Response to Cllr McAuliffe

19 August 2026.

Following receipt of comments from Cllr McAuliffe dated 20 July, please find below response prepared with input from the wider design team

Drawing Title
**DRAINAGE STRATEGY
SHEET 2 OF 2**

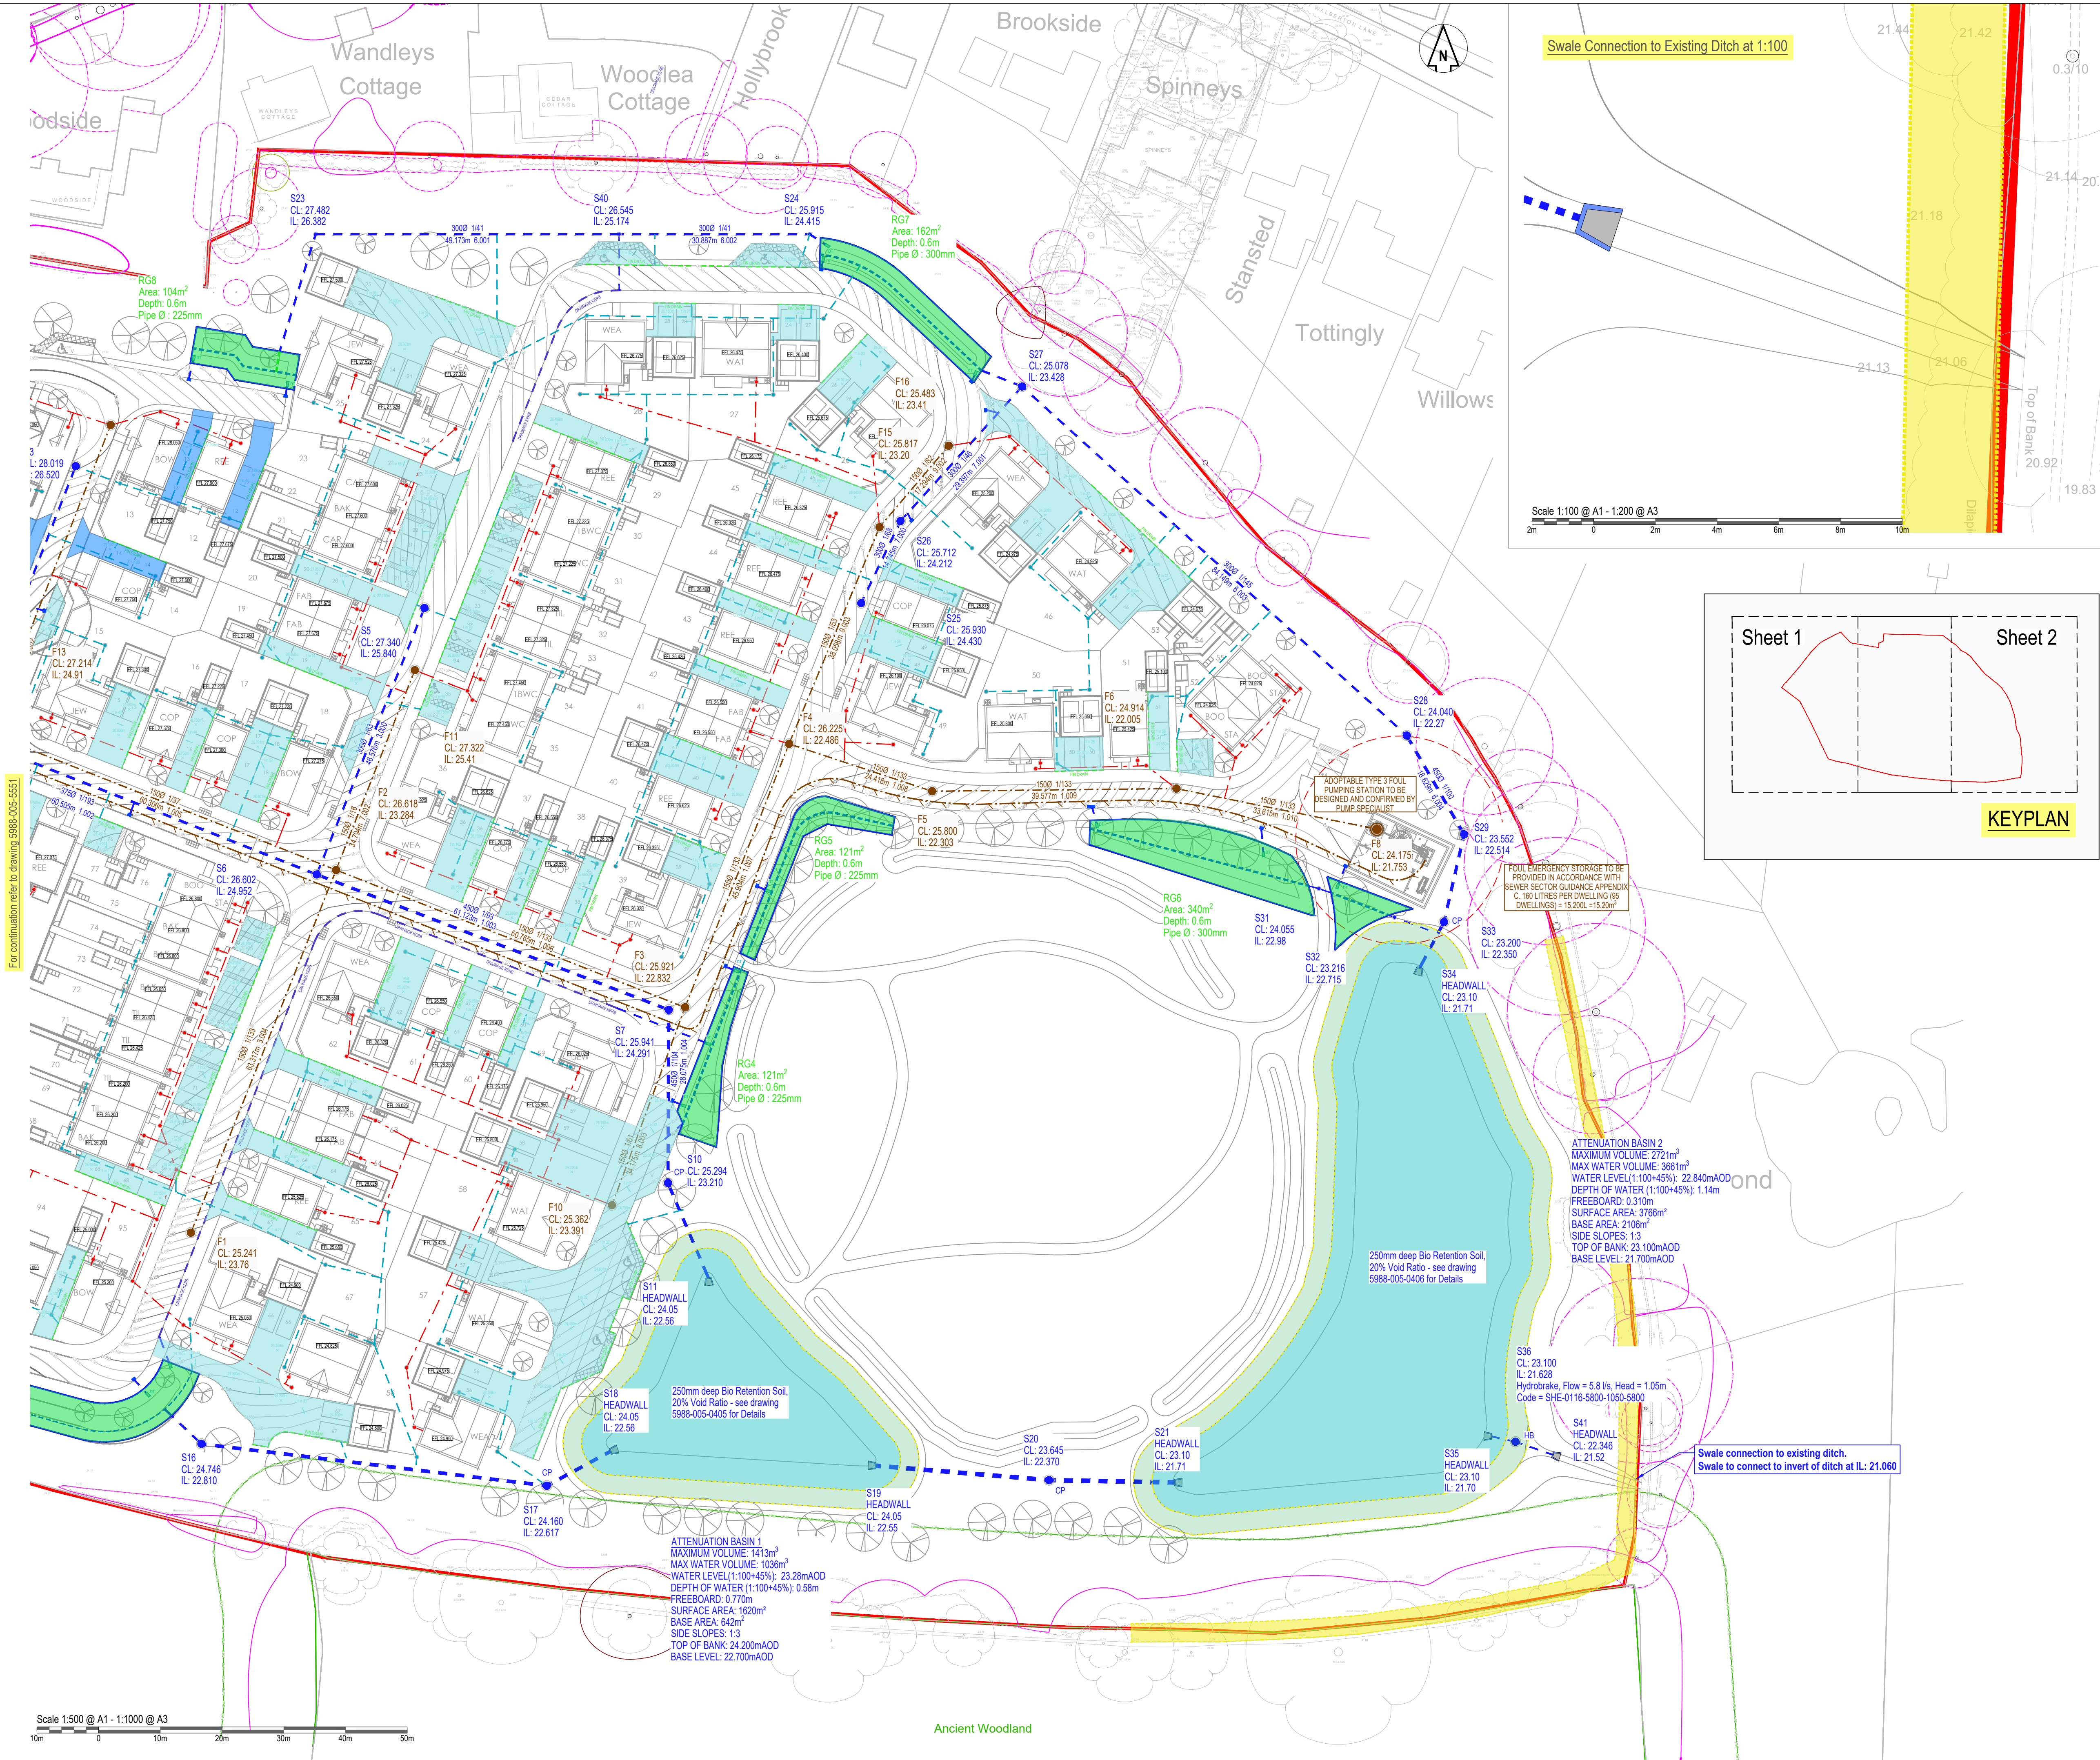
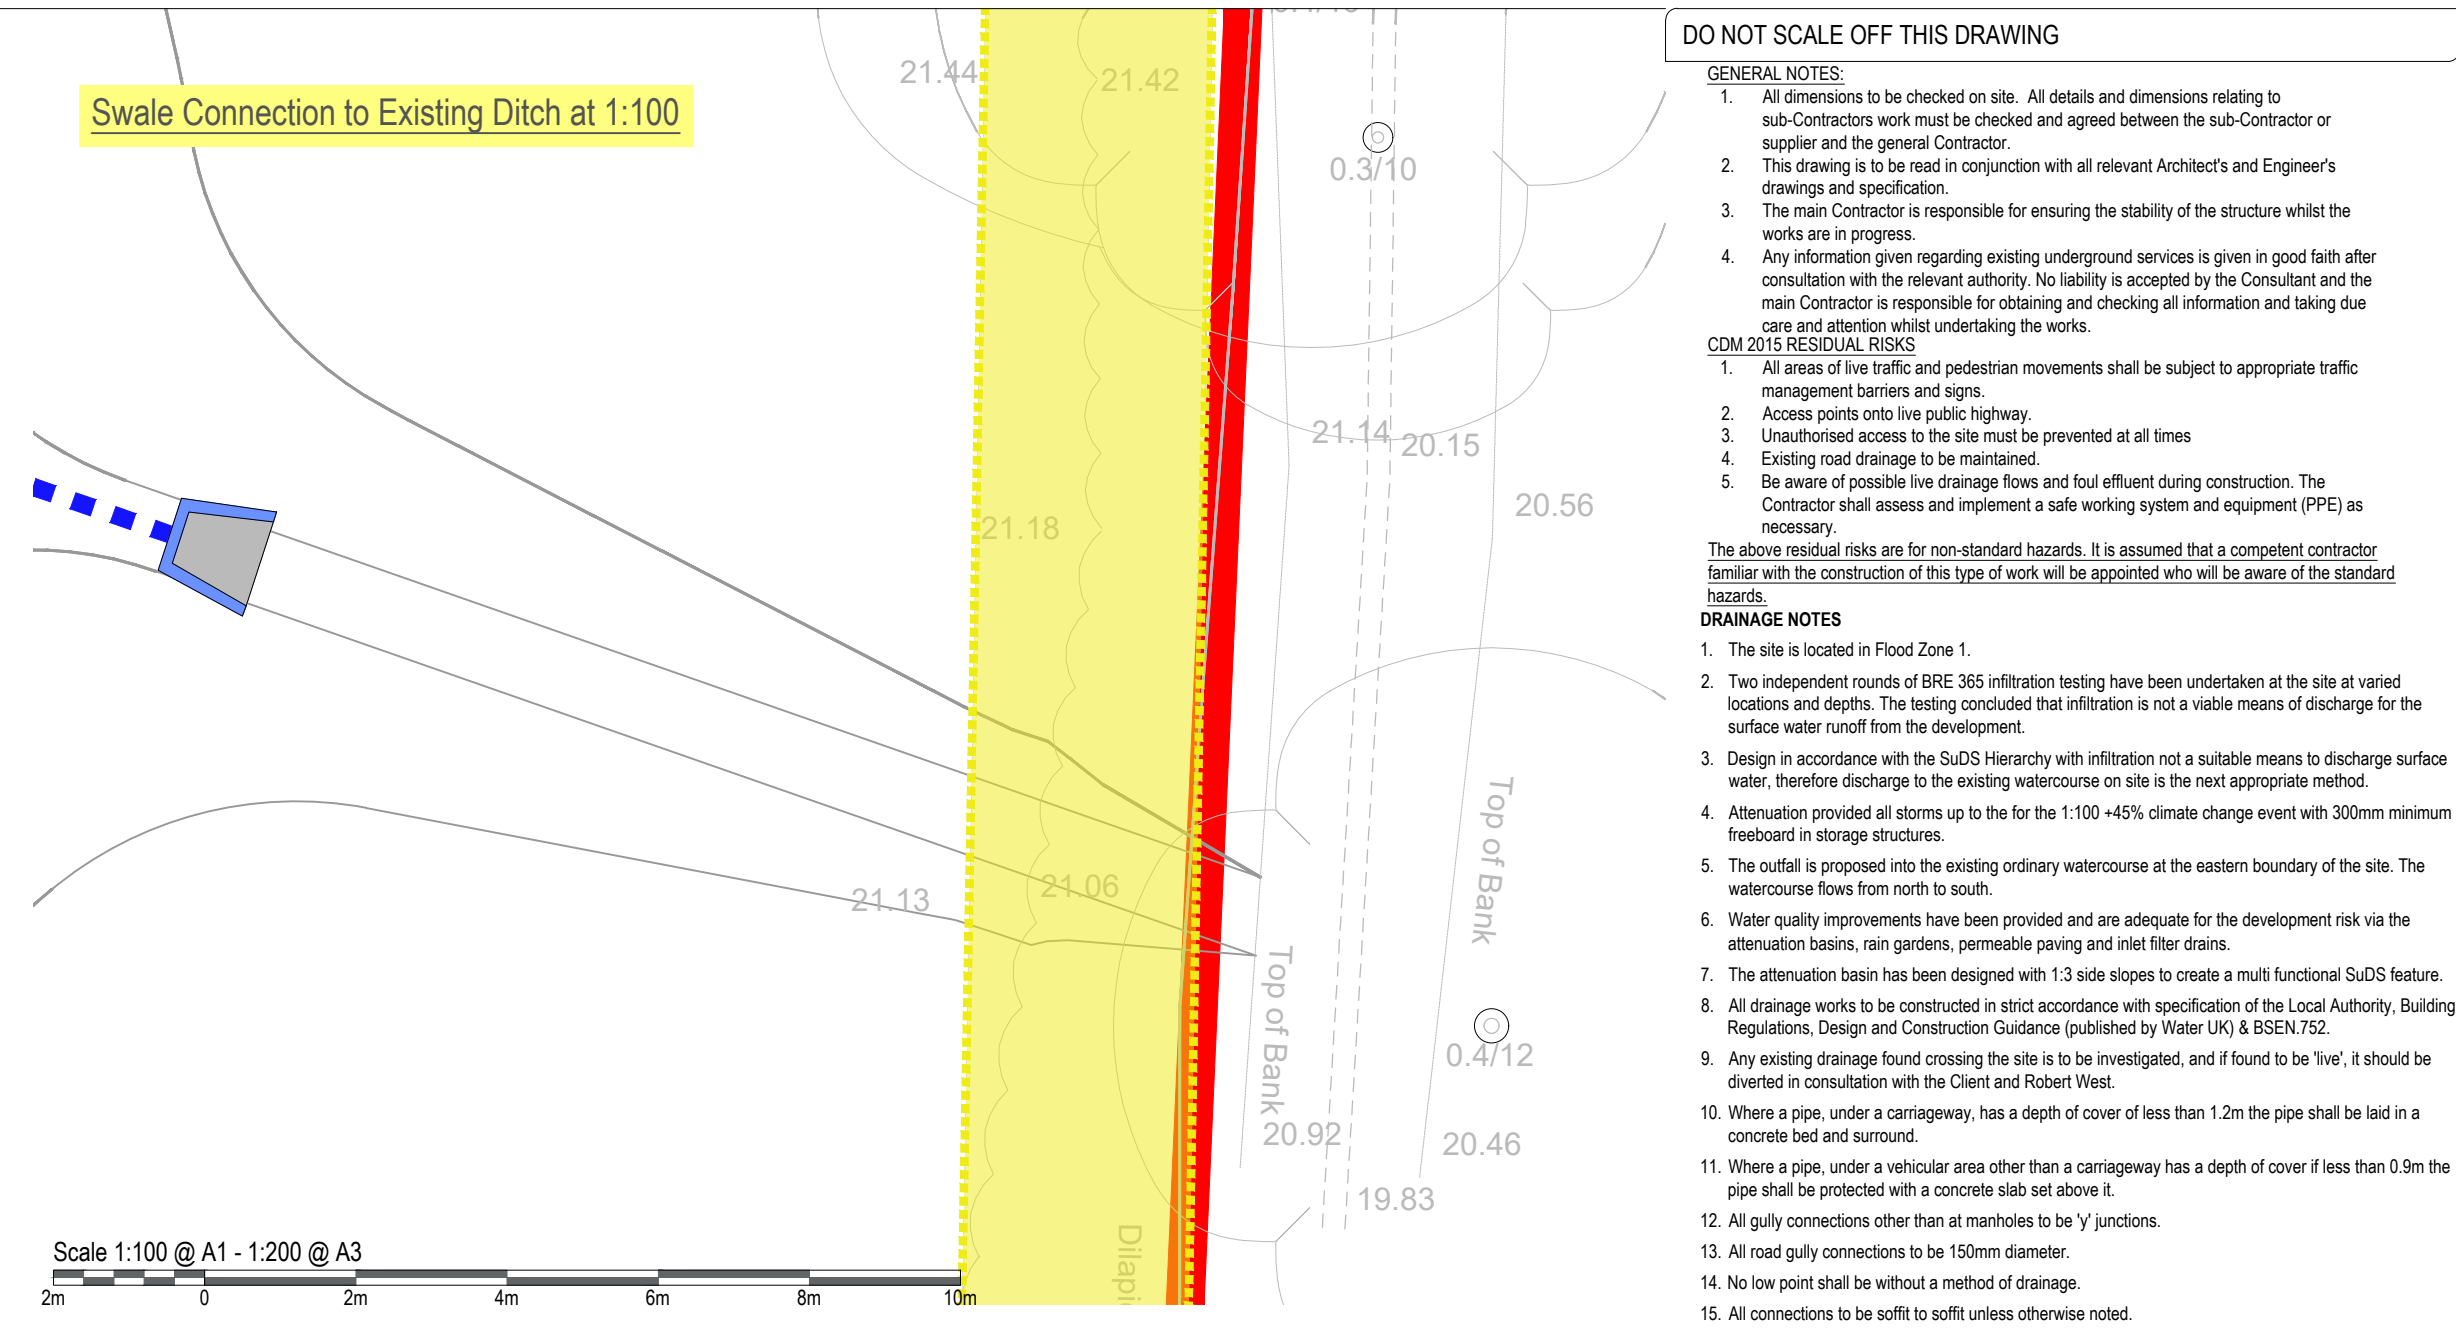
- **SuDS configuration and controlled discharge:** The lining, underdrain and outlet arrangements of the proposed SuDS features will be refined to allow infiltration in locations where ground and groundwater conditions are suitable, whilst retaining controlled overflow and exceedance routes for larger rainfall events. This provides flexibility to manage water appropriately without relying on infiltration where it may present a risk to groundwater or woodland conditions.

Drawing Title
**PROPOSED DRAINAGE DETAILS
SHEET 4 of 6**

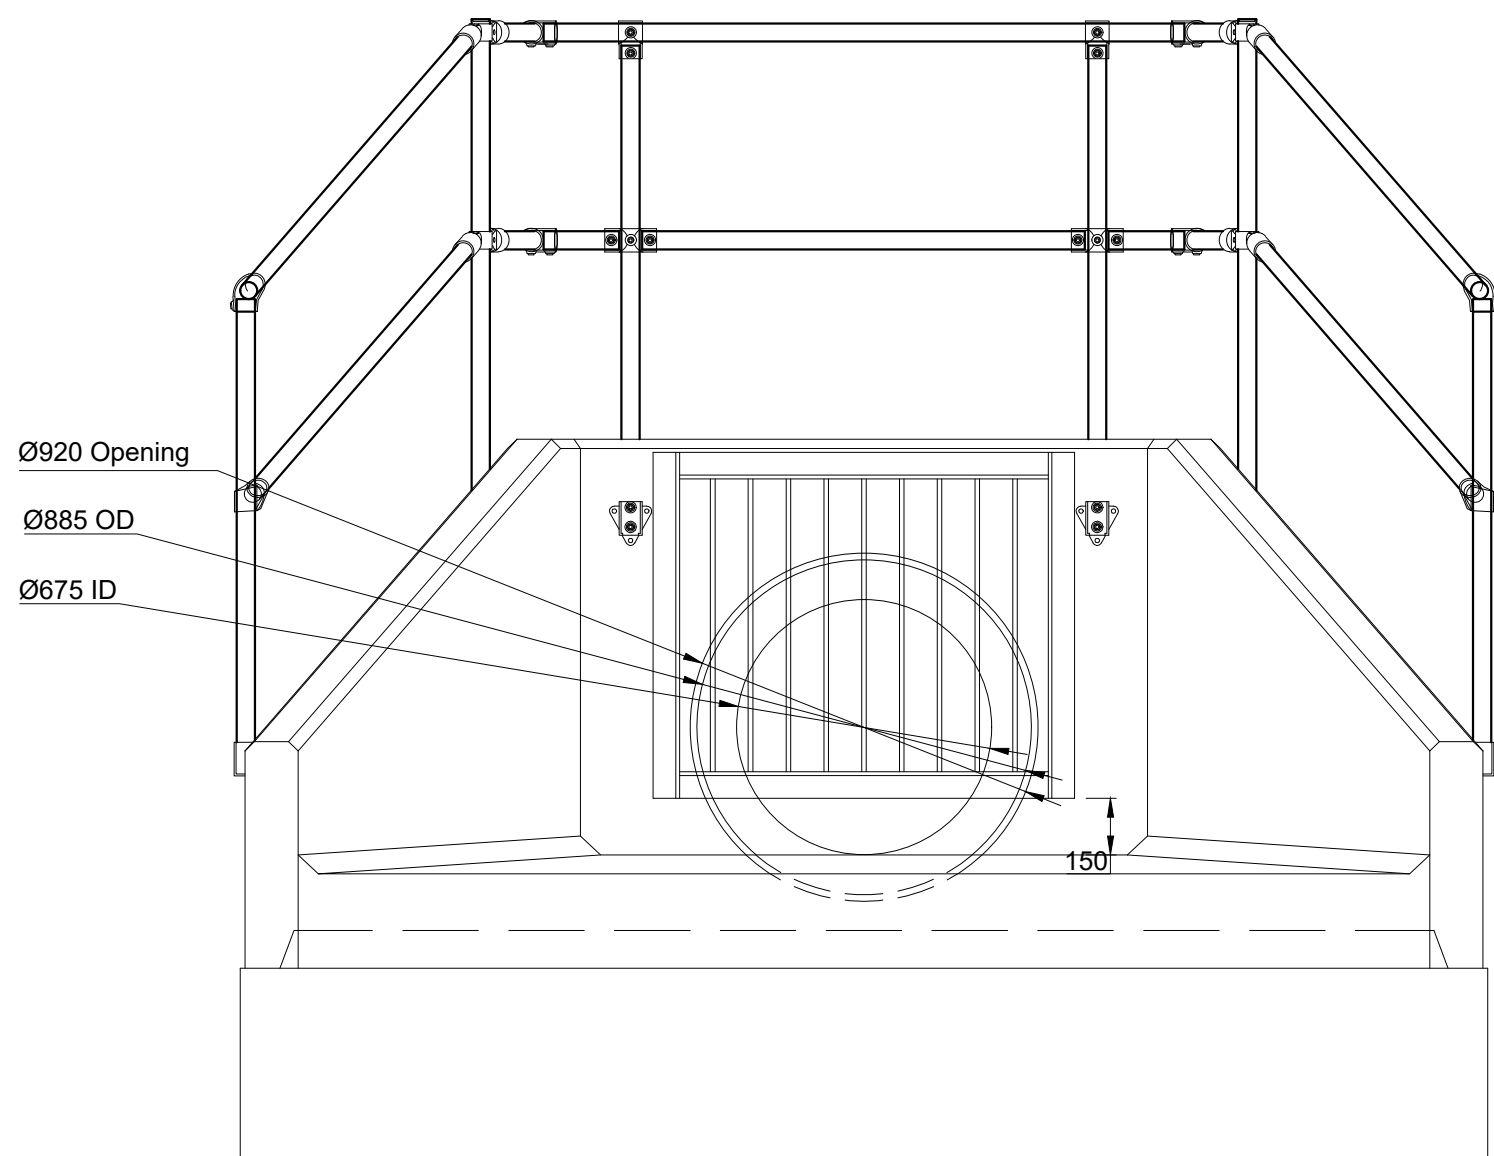
- **Infiltration and groundwater recharge:** Where groundwater levels, soil conditions and geotechnical constraints permit, unlined rain gardens, permeable paving and other infiltration features will be maximised within the development. Clean roof water can also be directed towards suitable infiltration or recharge features located between the development and the woodland, helping to maintain local recharge without introducing concentrated flows to the woodland.
